Planning Application Reference No.: 3/2026/0562

Address of Development: Blackburn Rovers Training Ground
Brockhall Village

**Objection to planning permission Ref. 3/2026/0562
Proposed Floodlighting and New Covered Seating
Blackburn Rovers Training Ground, Brockhall Village, Old Langho, BB6 8BA**

Drawing file: planx_downloads / 26_0562_Prop_Spectator_Structure.pdf

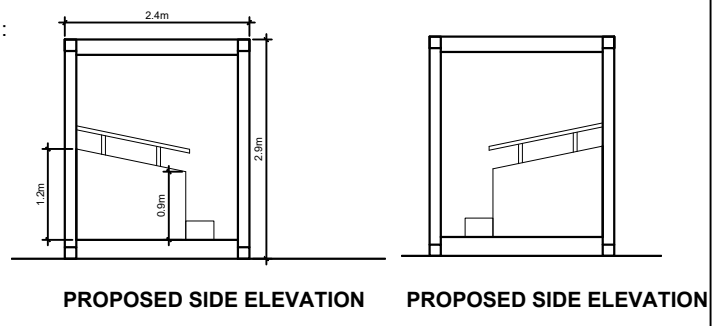
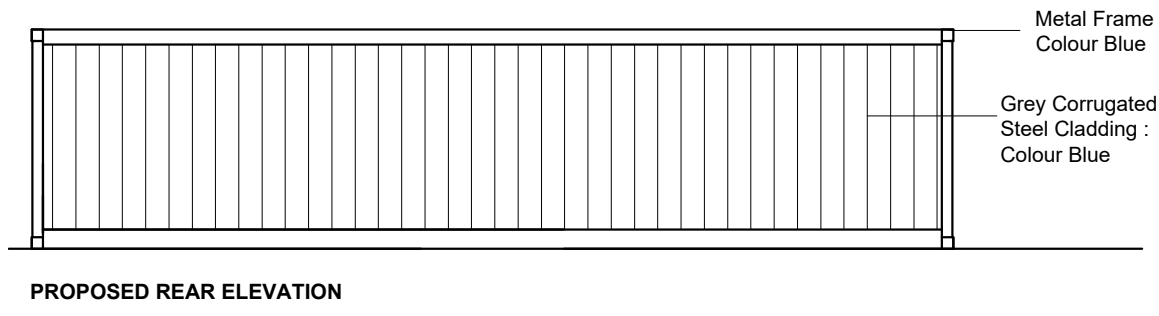
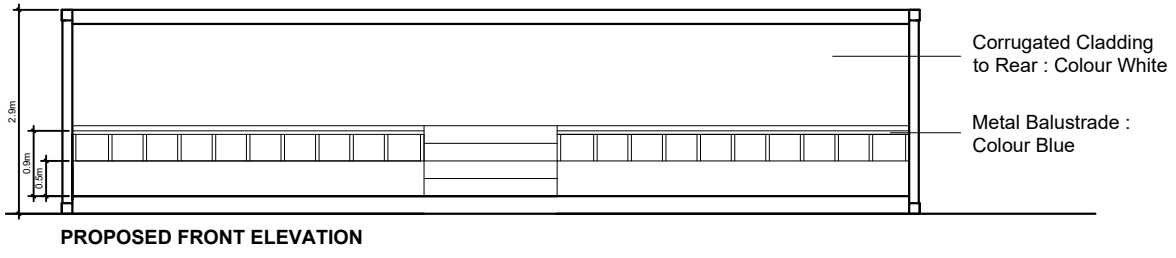
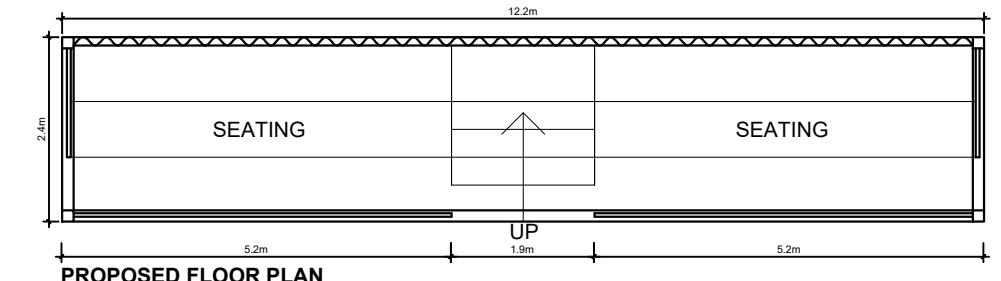
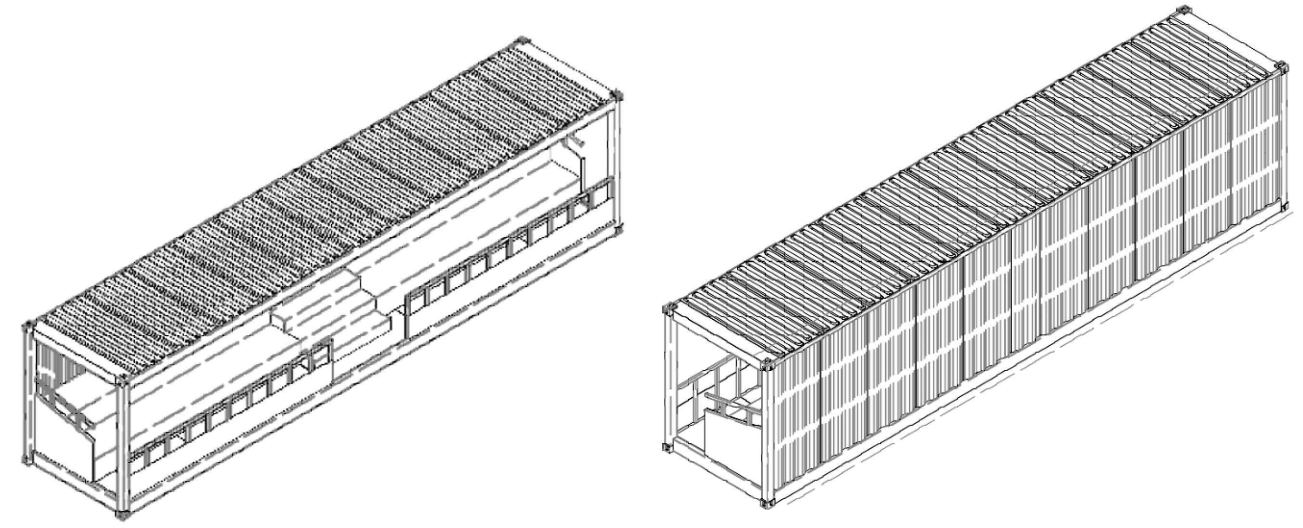
3. The application states only 160 on average attend the games at the academy , then why apply for 500 covered seating and standing areas?
4. The proposed "stands" are by admission basically containers - surely then a blot on the landscape ?

With regard to the spectator pods, 8 corrugated metal structures are proposed along the east side of the pitch. The Design and Access Statement indicates that the structures will provide seating for approximately 500 spectators, however in the absence of a plan and product data sheet which shows the internal layout of the structure this cannot be verified. This also means its design and capacity cannot be controlled. Furthermore, based on the illustrative image on the submitted plan it appears that the pods will have a capacity of greater than 500 spectators and that they will be moveable and could thus be moved around the application and wider site.
